Project No. 21071

**Re: SUB22-002 (Design Built Homes Preliminary Short Subdivision)
Request for Information #1
4719 86th Ave SE**

This letter is provided as response to comments dated September 12, 2022. Each item has been carefully reviewed and considered and the following is a summary of how each item was addressed.

DRAWING: C2
SHEET: 2 OF 4

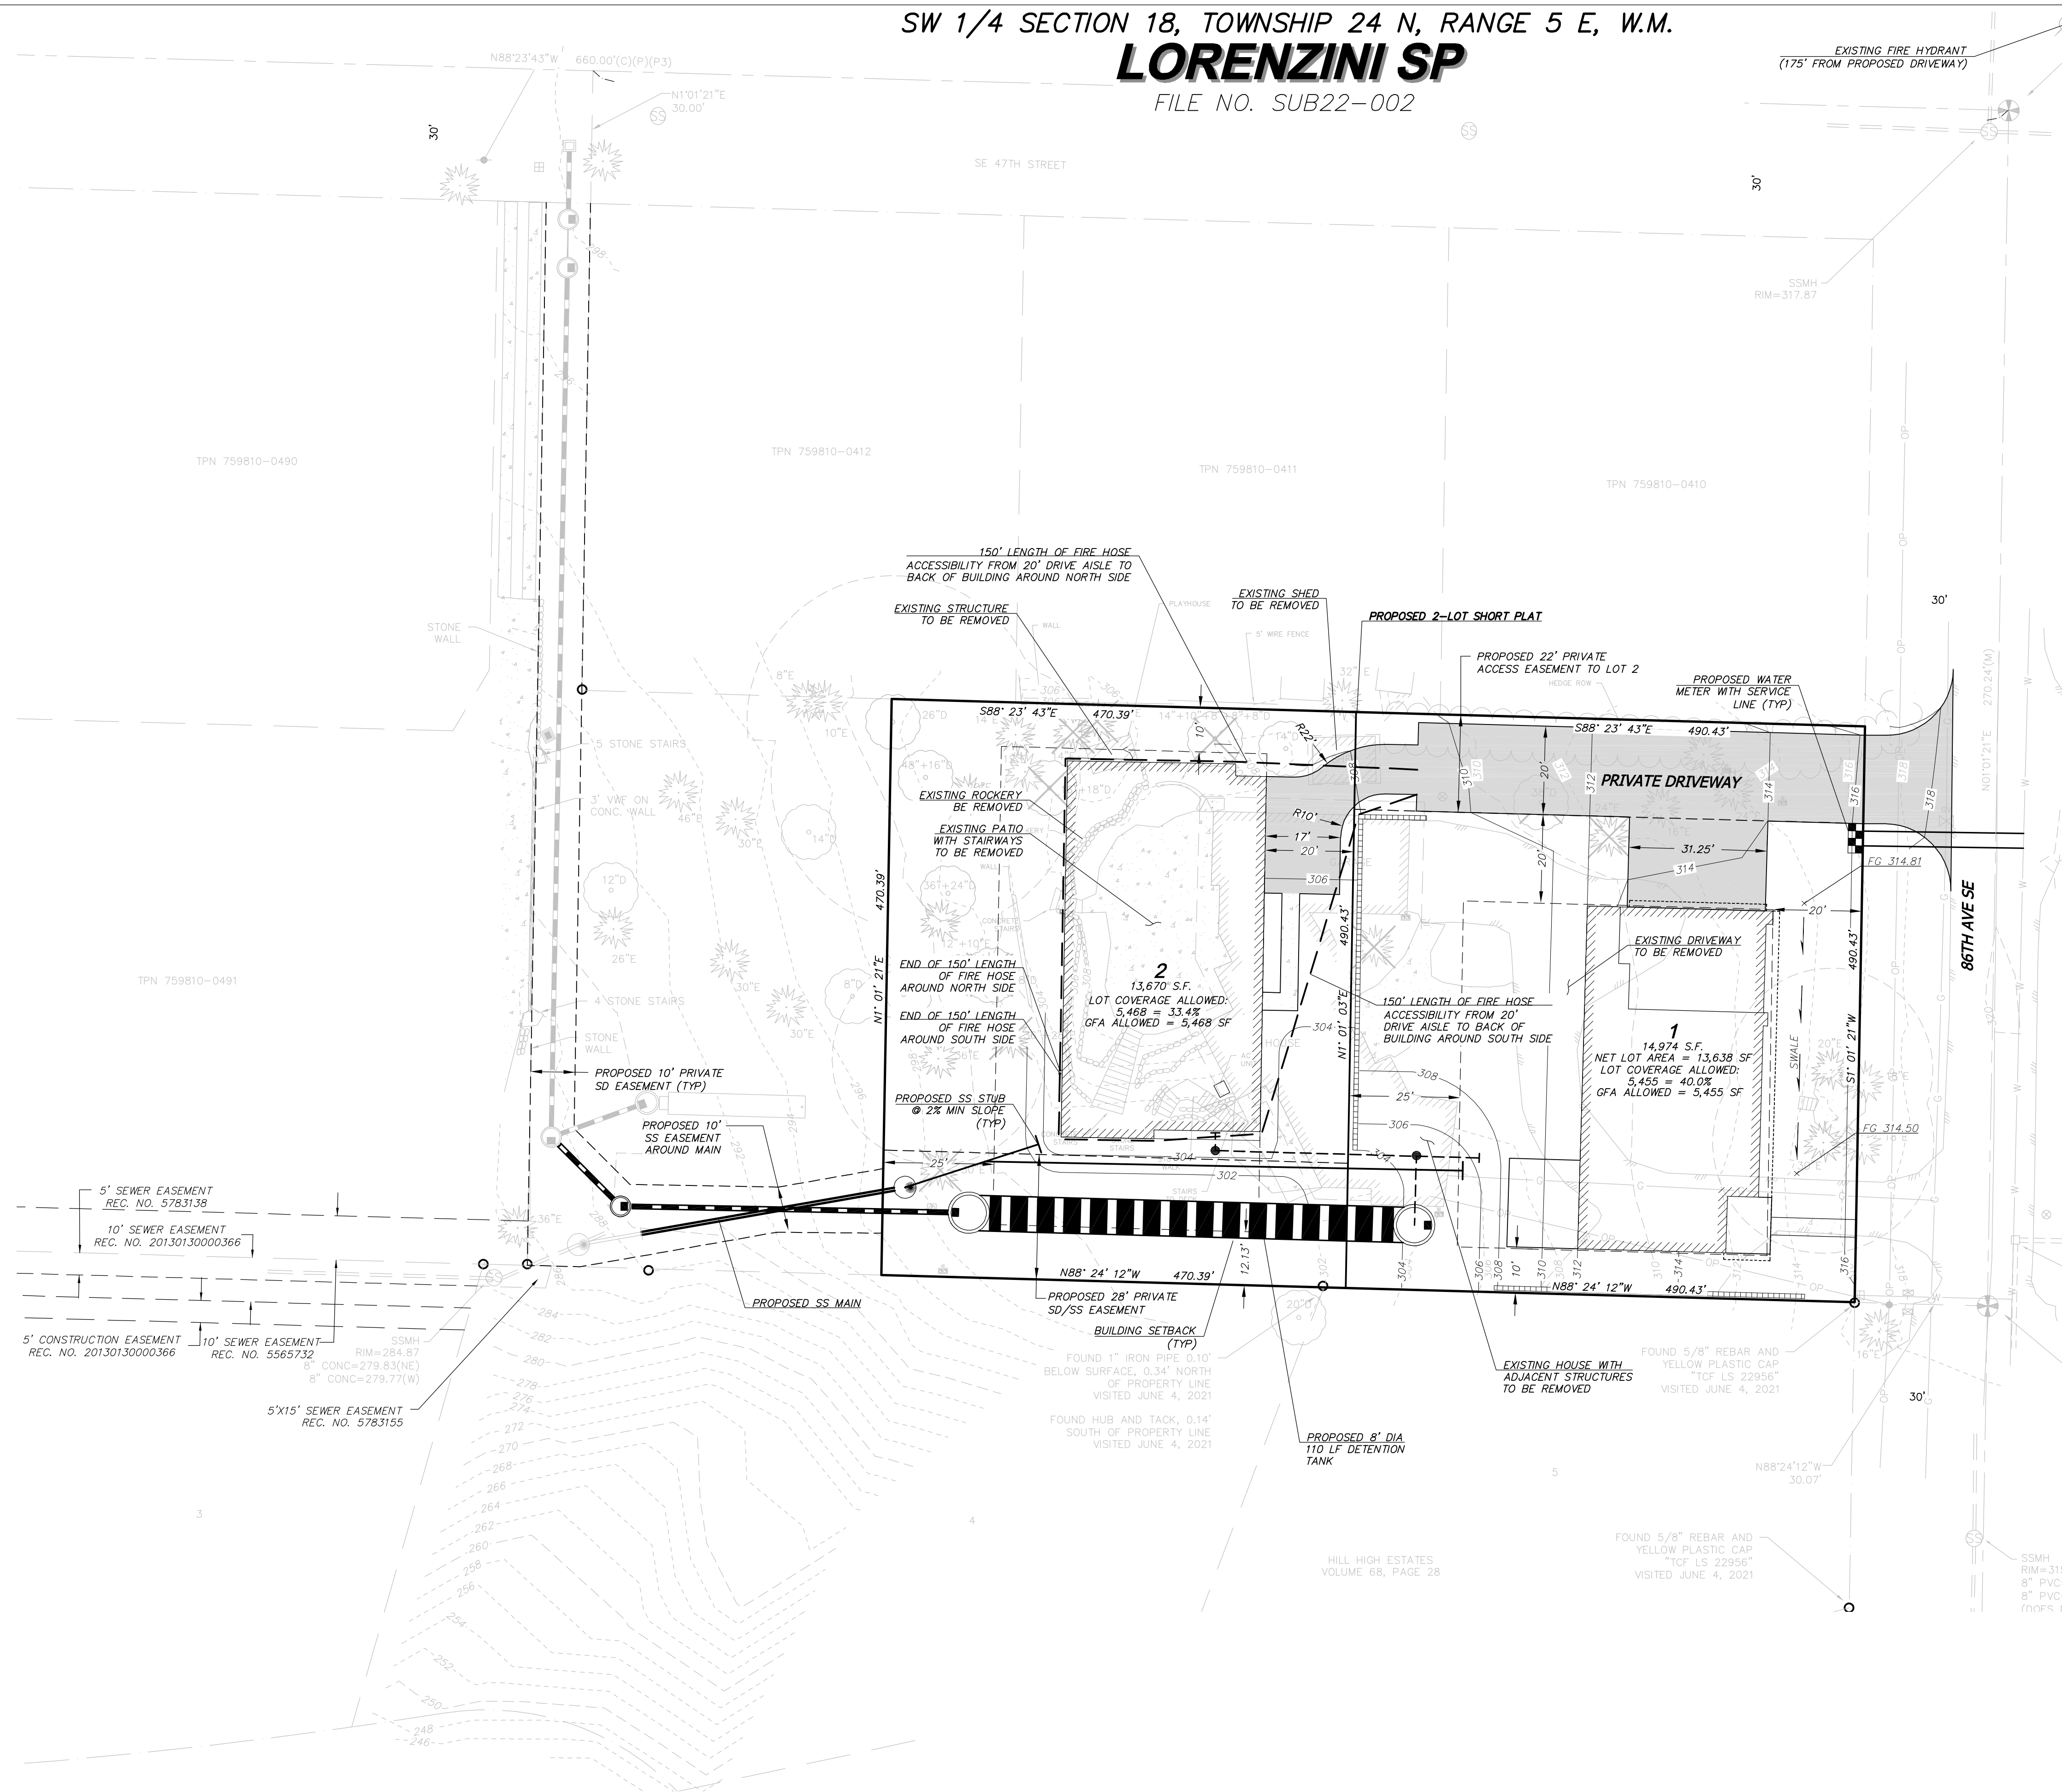
3. MICC 19.02.020(C)(1)(c)(i)((b)) states that for lots with a lot width of more than 90 feet, the sum of the side yards width shall be a width that is equal to at least 17% of the lot width. Based on the width of Lots 1 and 2 on the development plan set, the side yard setbacks for both lots would need to add up to approximately 22.13 feet. Please revise the side yard setbacks shown on the development plan set.

6. Please clearly distinguish if the 22-foot access easement on the north side of Lot 1 is private or public, existing or proposed, and for which lot the easement is benefiting.

8. The driveway width must be increased to 20 feet all of the way from Lot 1 to Lot 2, or within 150 feet of the furthest point from the City road.

Lot 2 side setback has been revised to be 12.13' at the southern property line. The setbacks now sum to 17% of the lot's width at 22.13'. Lot 1 complies.

The 22' access easement is a proposed private access easement to provide access to Lot 2. The label has been revised.

Distances are shown on the Site Plans to prove that the distance from the end of the 20' drive to the back corners of the Lot 2 building are less than 150 feet.

TREE PLAN

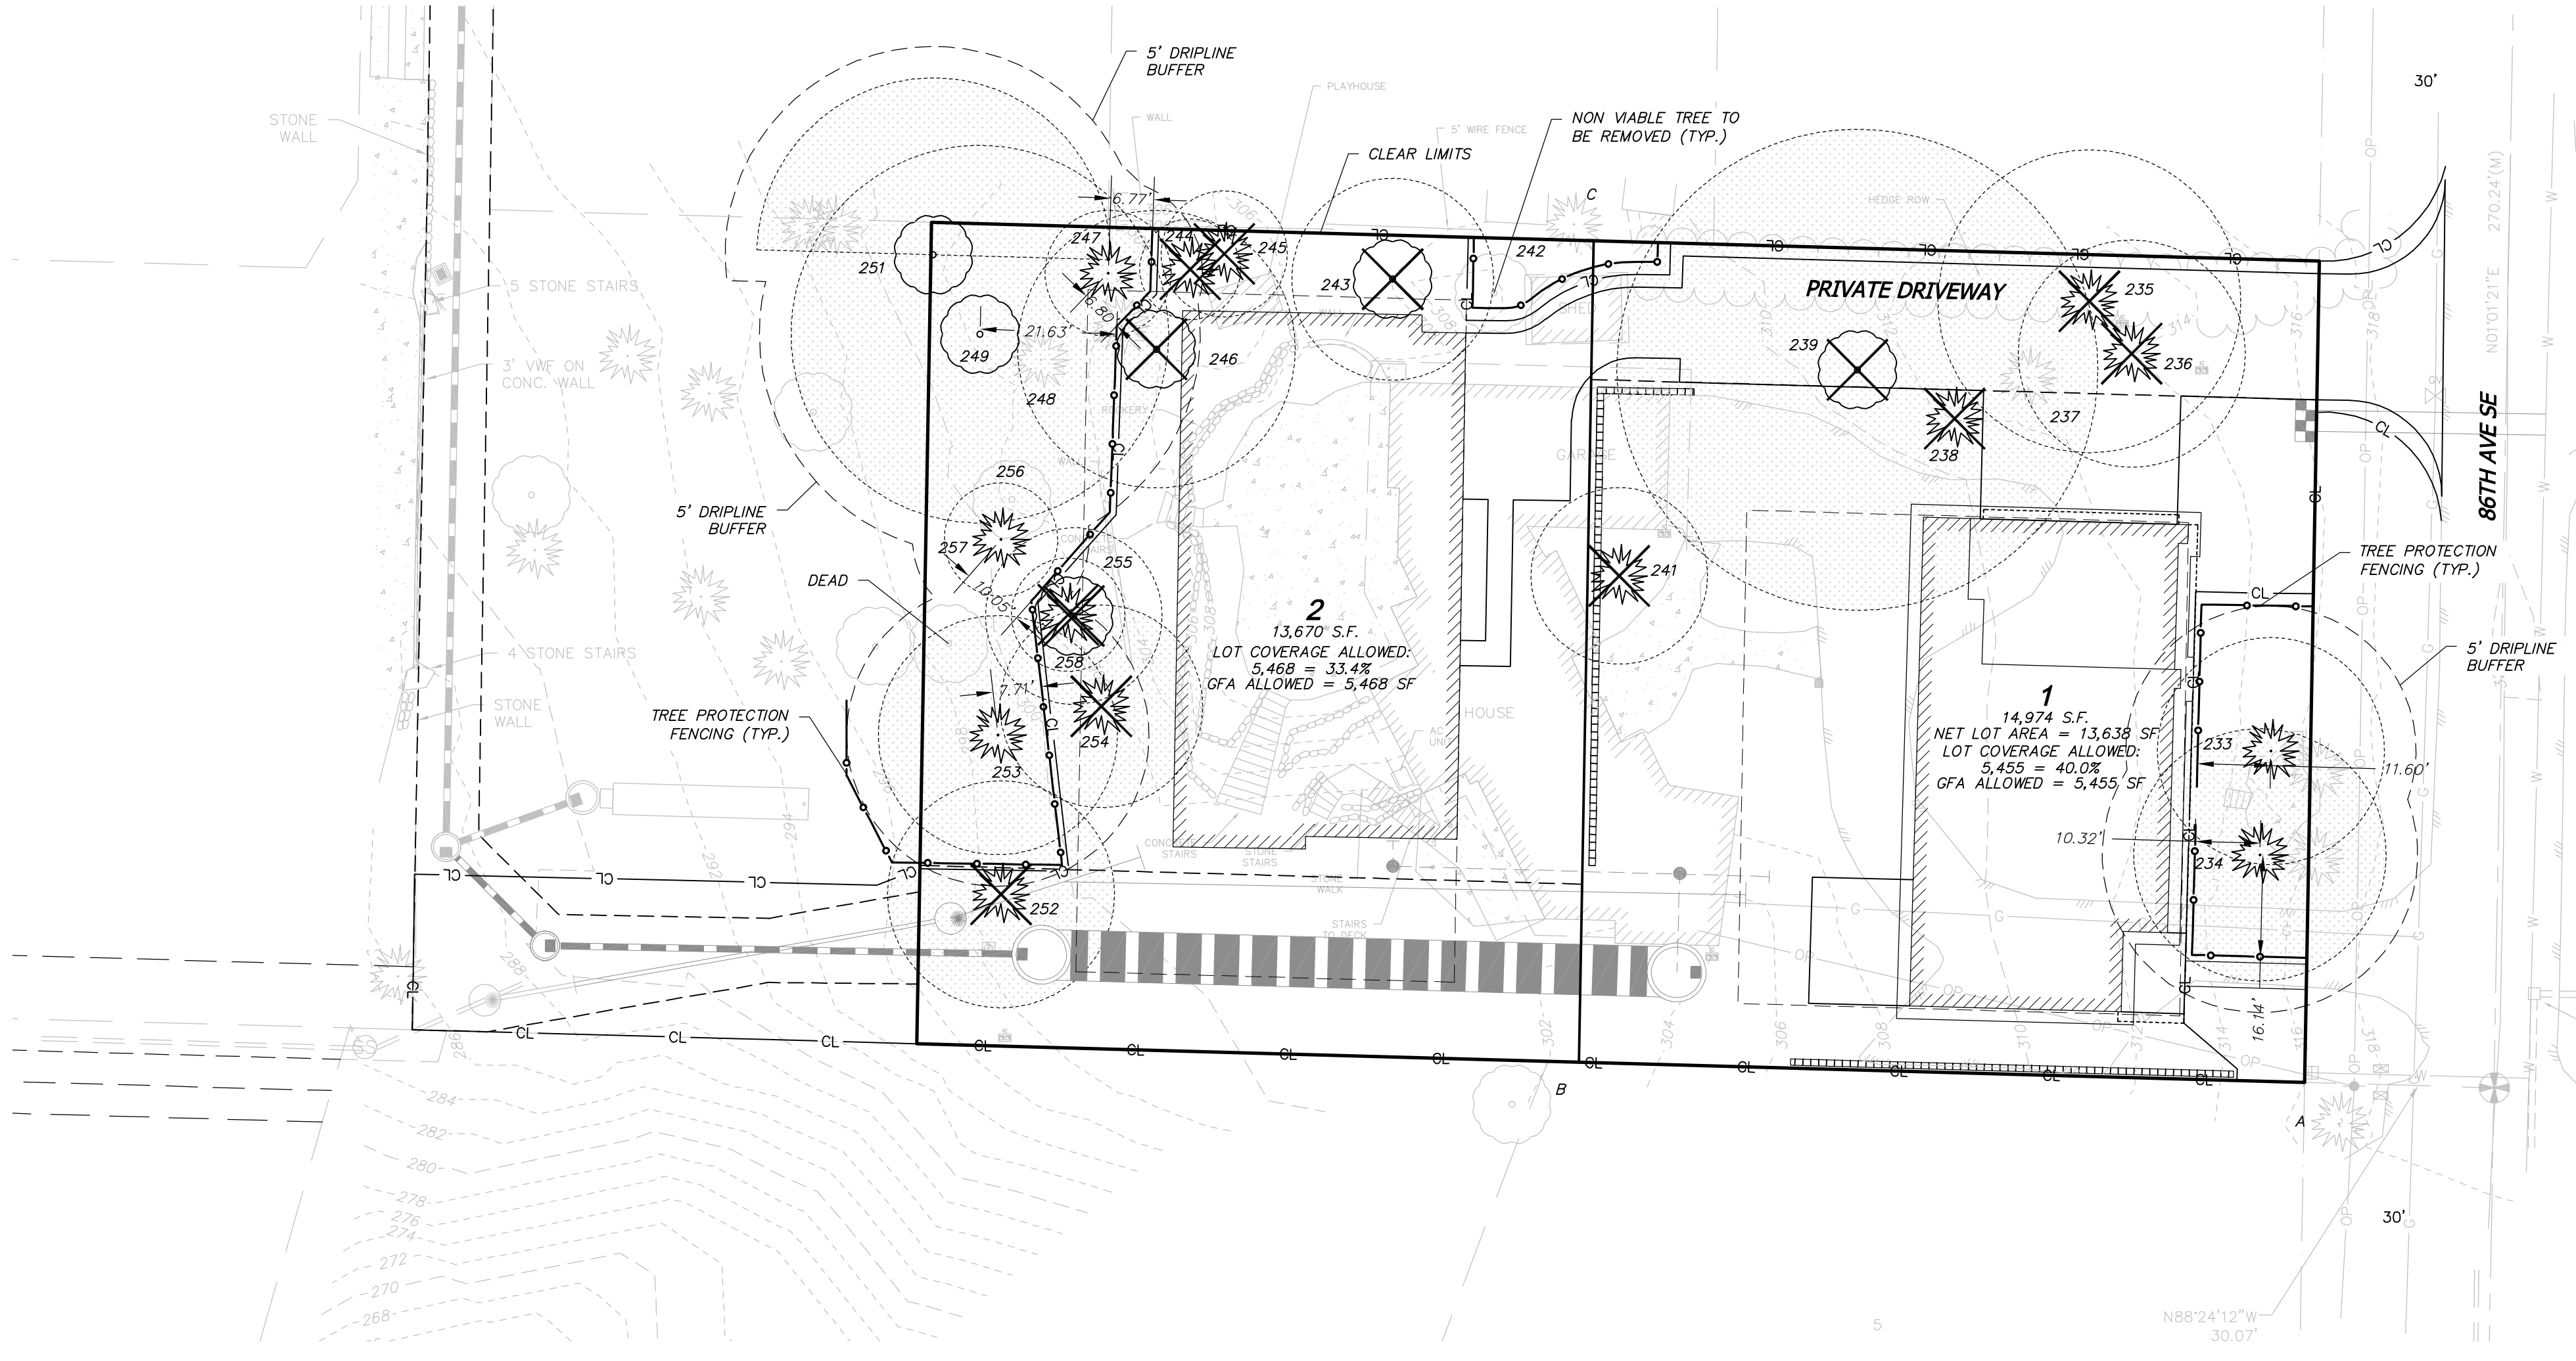
9. Please either move the building pad and over excavation of Lot 1 outside of the critical root zones of trees 231-234 or provide an air excavation analysis that demonstrates that these trees would not be damaged by the work. The analysis will need to call out specifics of the project design. Alternatively, these trees could be proposed to be removed if the minimum required number of regulated trees will be retained.

10. Trees 239 and 254 are exceptional in size and in fair condition. Please either protect the trees according to the arborist-given driplines or justify their removal of the trees under MICC 19.10.060(A)(3).

The building pads will remain as shown. An air excavation analysis will be provided to demonstrate that trees 231-234 will not be damaged during construction.

Tree 239 is located in the proposed private access easement which is required to provide a 20' width drive aisle from the existing roadway to Lot 2 per Fire Marshal.

Retention of tree 254 will prevent creation of a residential lot through a subdivision or short subdivision that is otherwise allowed by MICC 19.10
